**APPLICATION NO:** 24/00072/FUL/ADDINF

**DESCRIPTION:** Proposed erection of single storey rear extension.

**LOCATION:** 11 Waterhouse Mead College Town Sandhurst

Drawing Title  
Block Plans

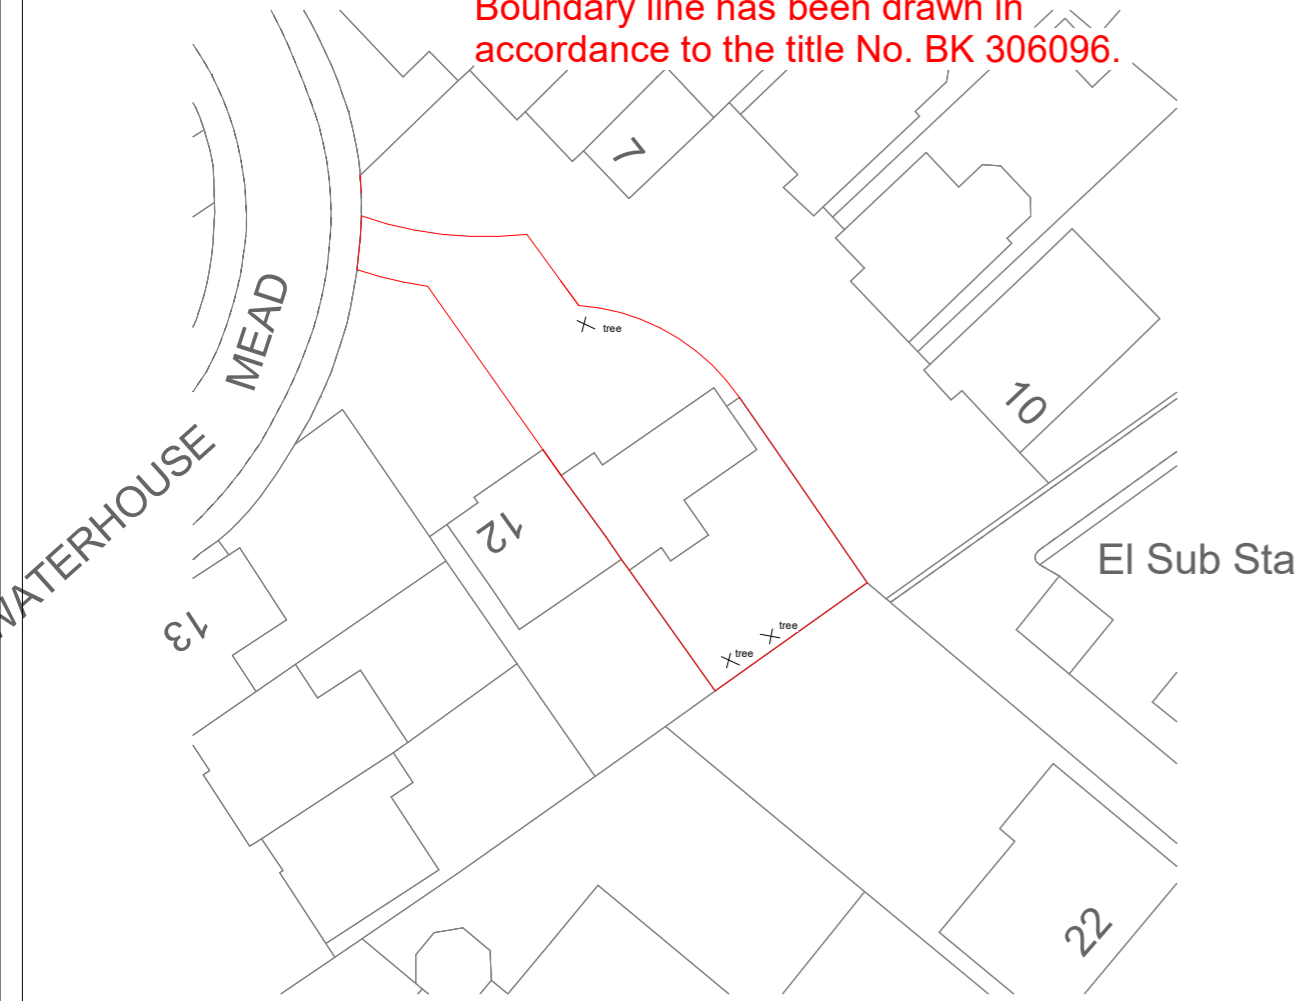
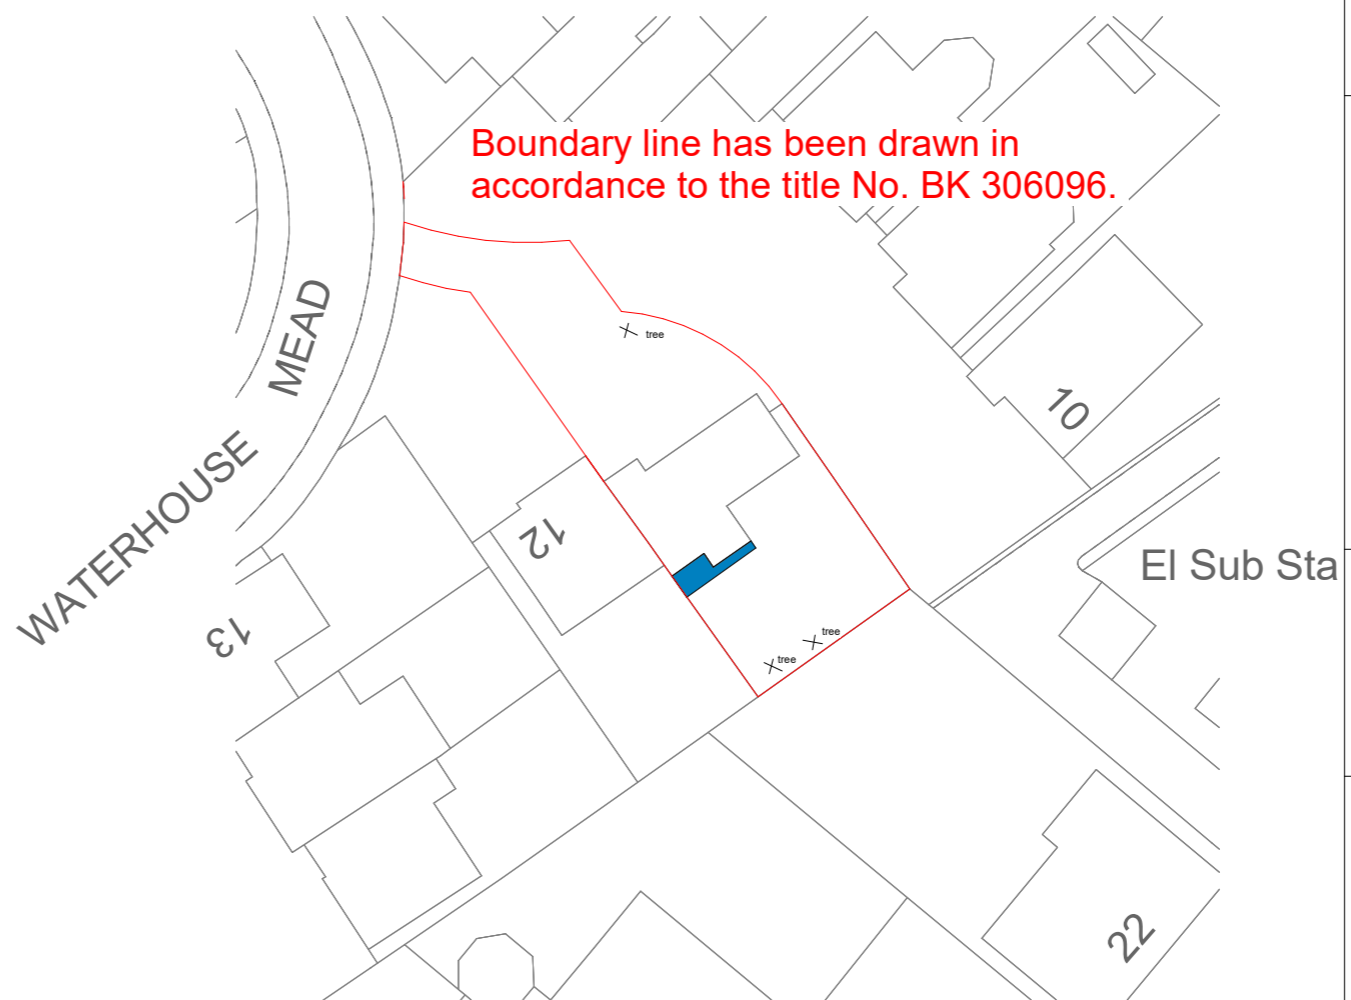
- 1 Please amend the red line of the site location plan to extend to the public highway. Also as this property shares a driveway with other properties please complete Certificate B instead of Certificate A on the application form.
- 2 Please amend the scale bars on plans 4-10 as they show that they are scaled at 1:500 instead of 1:100.
- 3 Do not submit the amended plans / information via the planning portal. Please email directly to myself.
